Your Ref: OWPC15497
Our Ref: A/121/17/HH 21-06-2017
Please ask for:
Mrs A Gardner

Town & Country Planning Act 1990 (as amended)
Town & country Planning (Development Management Procedure) (England) Order 2015

Single storey extensions to existing garage and pool
Harcourt West Drive Angmering

PROPOSED ELEVATIONS SINGLE STOREY EXTENSION TO EXISTING GARAGE AND POOL ENCLOSURE

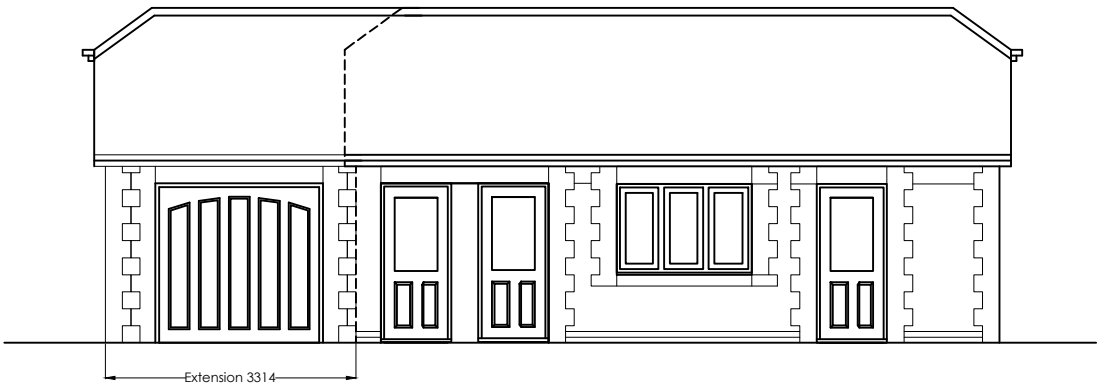
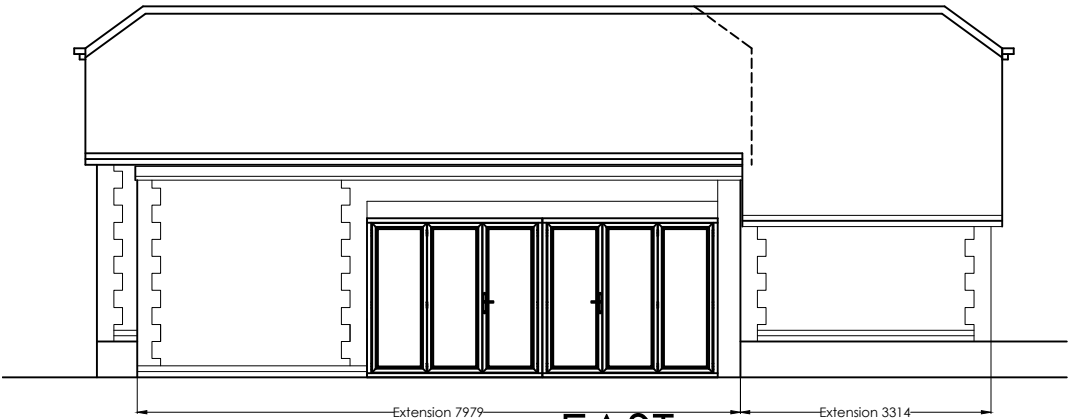
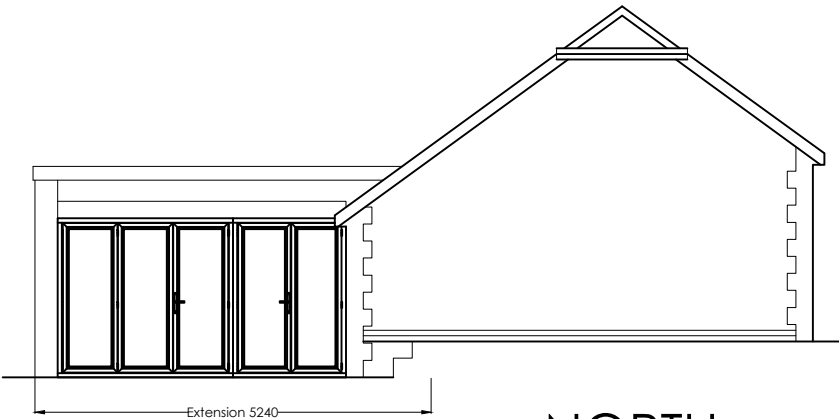
*However I do object to the proposed building covering the pool.
It is outside the original curtilage of the site and further obscures the siteline from the adjoining road onto West Drive.
It also has a flat roof which is not appropriate in this very visible location.*
